**SUBJECT: SF-18-025 – Ellicott Town Center Filing No. 1
Response to County PCD-Engineering Review Comments**

In conjunction with our final plat re-submittal, this letter provides responses to the review comments detailed in the Memorandum from PCD-Engineering dated May 26, 2020. These review comments are specifically addressed as follows **(Applicant responses are annotated in bold / red / parenthesis following each County comment):**

PCD Memorandum dated May 26, 2020

TEMPORARY POND C2.8 PLAN

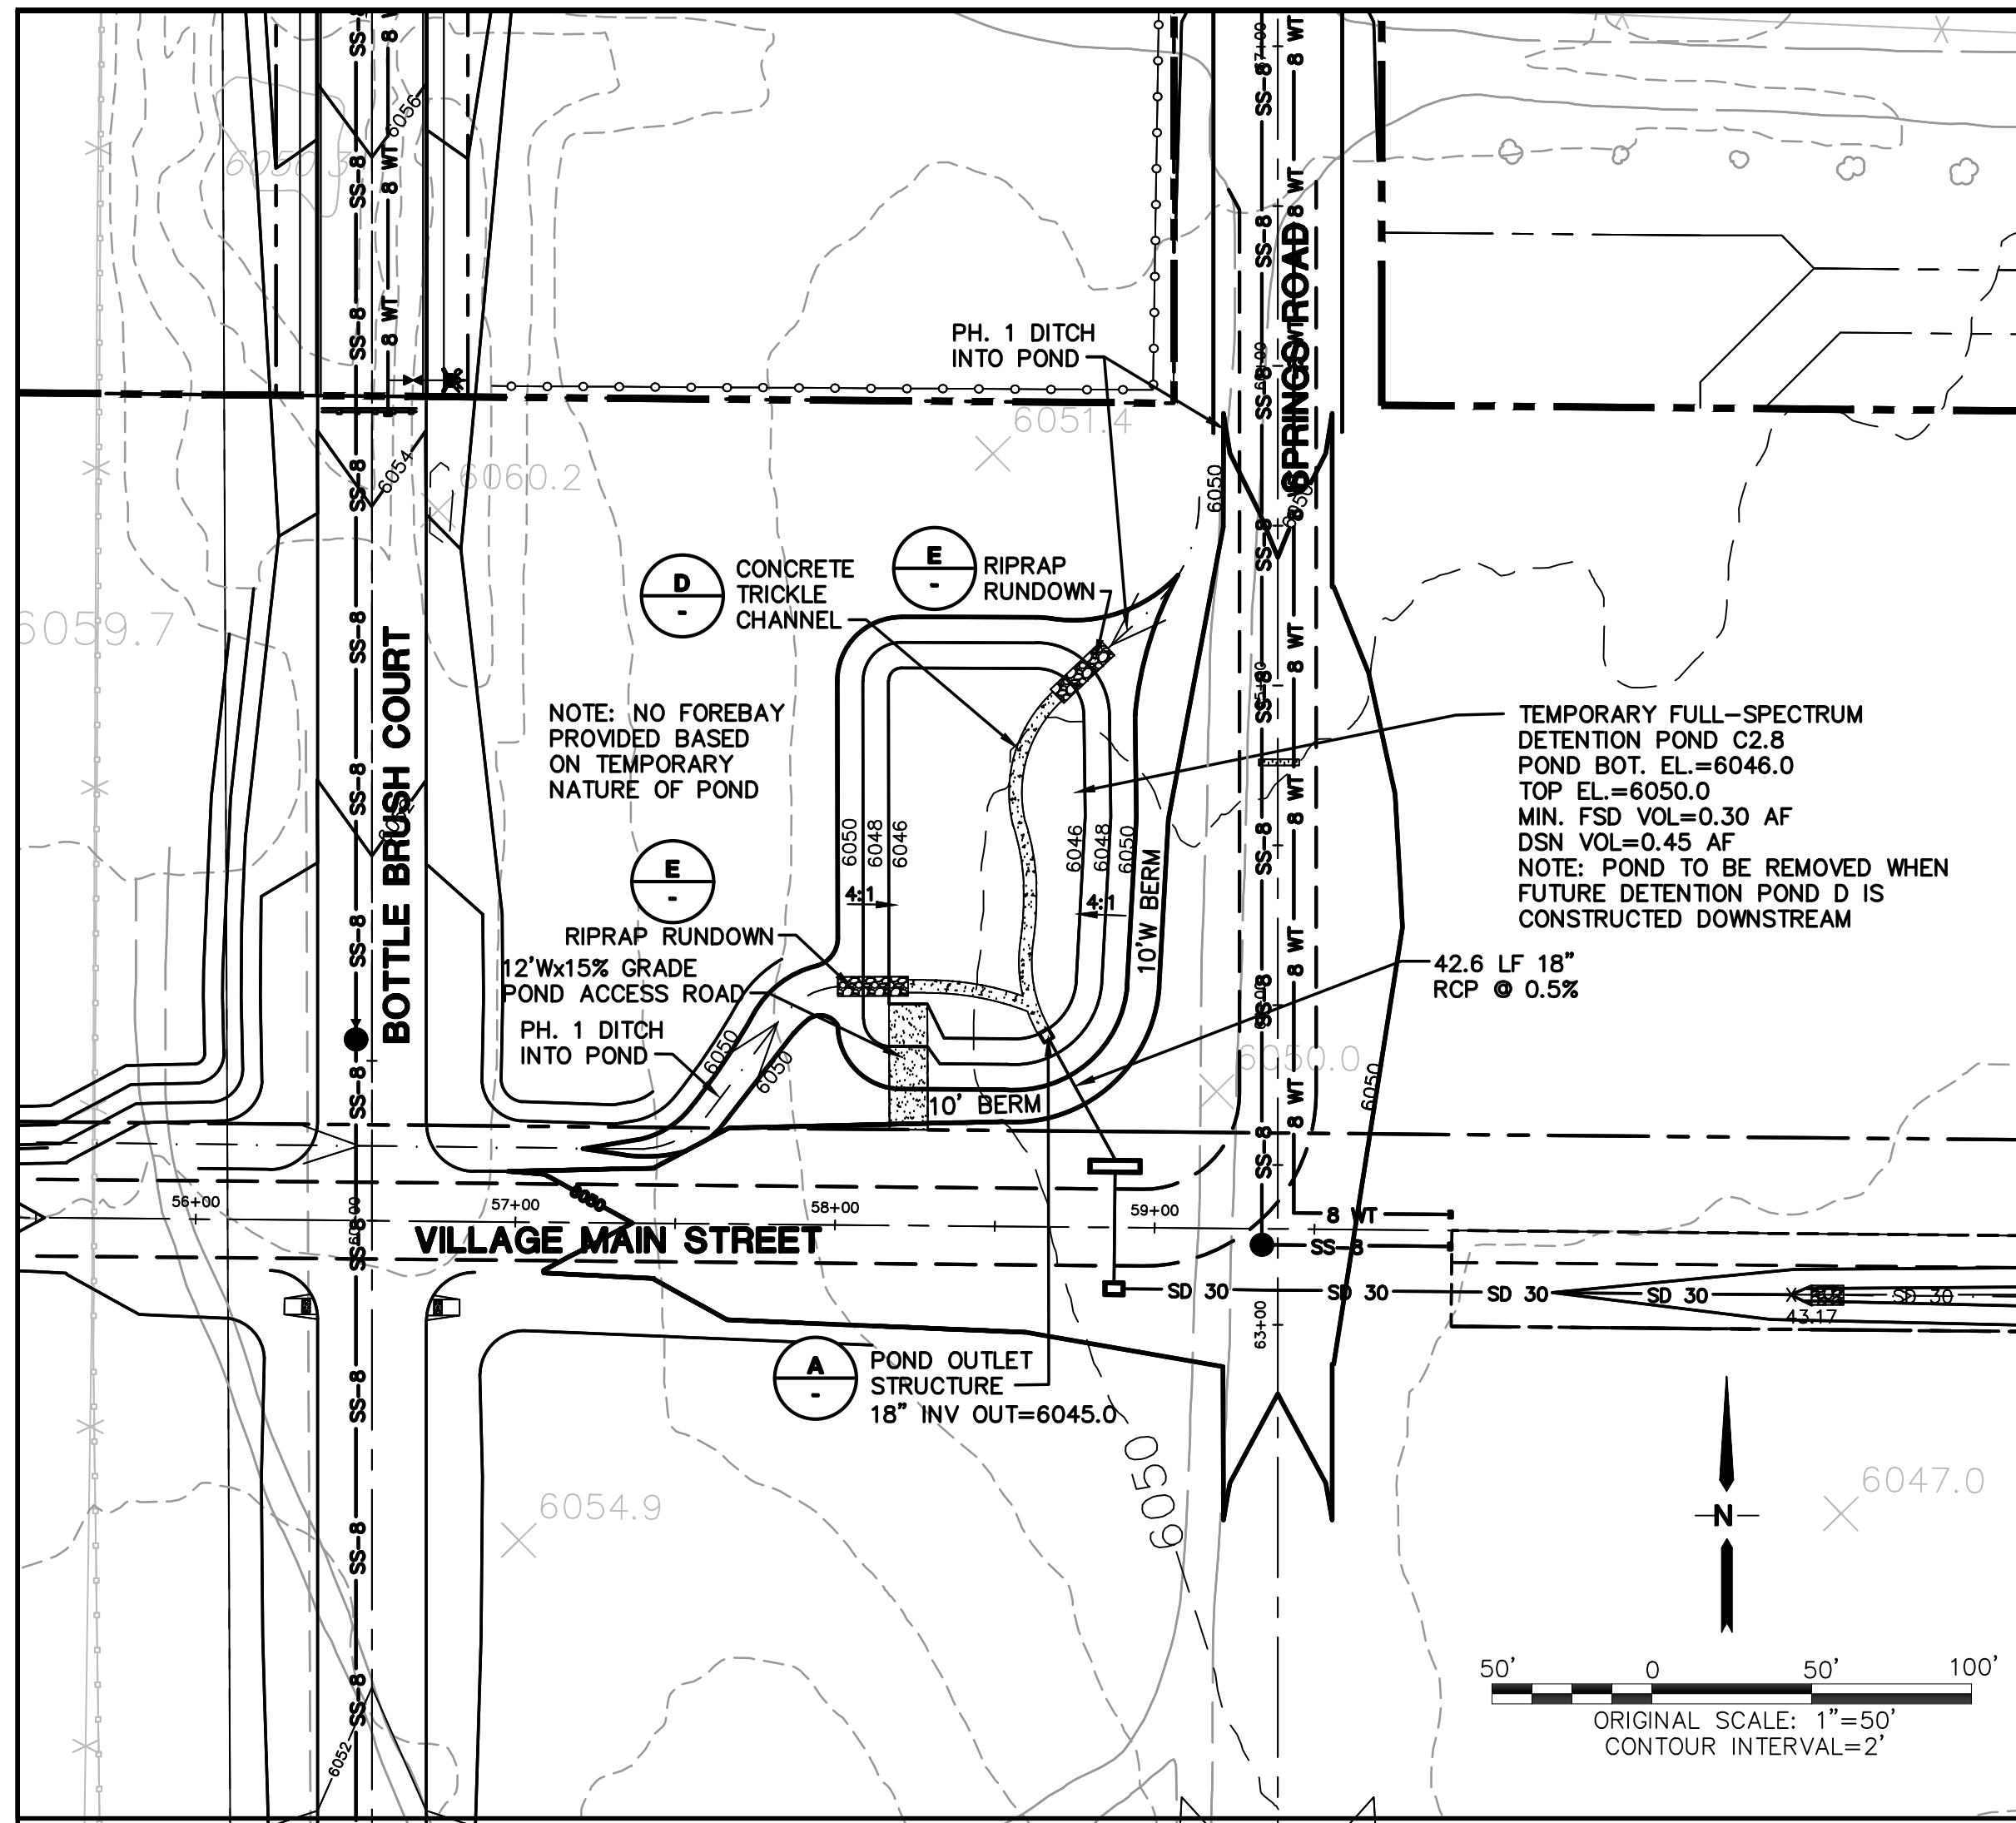
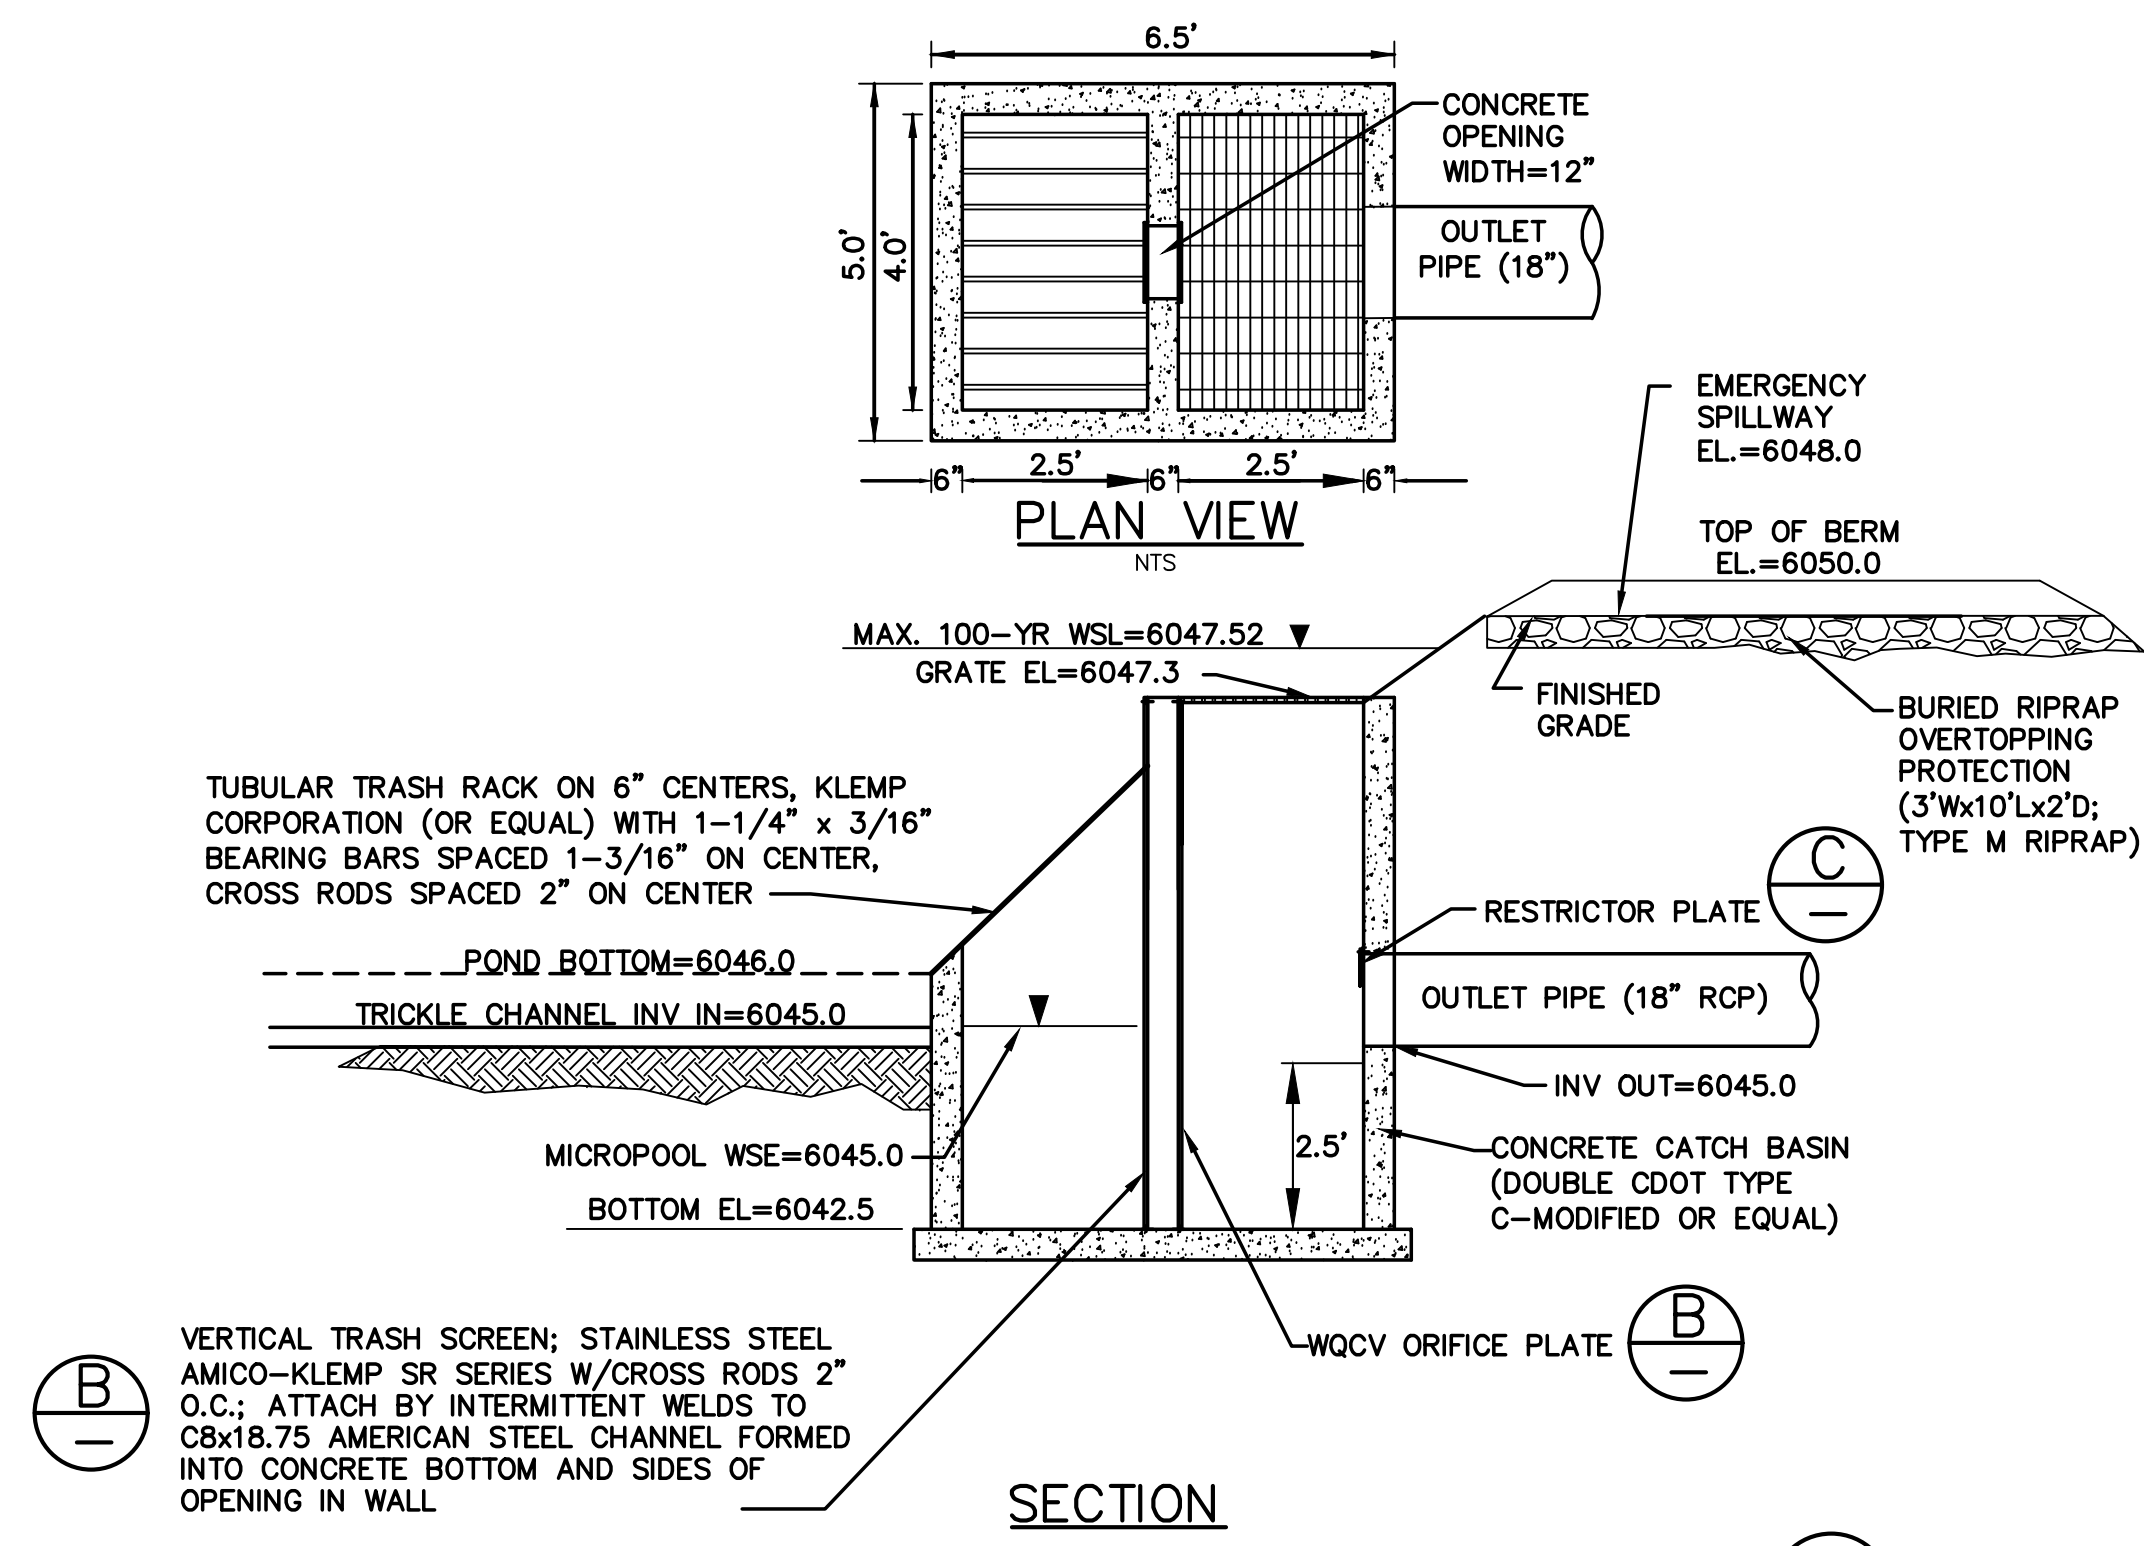
- b. The deviation request for the temporary FSD design requires more description/justification in the second box of Page 3, “The deviation will achieve the intended result with a comparable or superior design and quality of improvement.” This is in regard to the trickle channel. *Additional detail is required regarding where flows enter the pond, trickle channel alignment, and potentially rock/berm (to act as forebays) locations. Discuss with Staff. (Revised Sh. C1.6 to show Riprap Rundowns entering detention pond with Boulders to serve as forebays)*

7. *Resolved.*
8. Provide approved CDOT plans for PCD file. *Provide when available.*
9. Note: temporary pond C2.8 design may require revisions depending on approval of deviation request. Staff believes approval of the deviation will be more likely if the pond is provided with some form of trickle channel(s). **(Concrete trickle channel has been added on Sh. C1.6)**

2. *Resolved.*
3. Show and label maintenance access roads on the plans. Unresolved; see redlines. Partially resolved; additional detail is needed at the southwest corner of Pond C2.8. *Unresolved; please discuss with staff. (Additional detail provided on Sh. C1.6)*
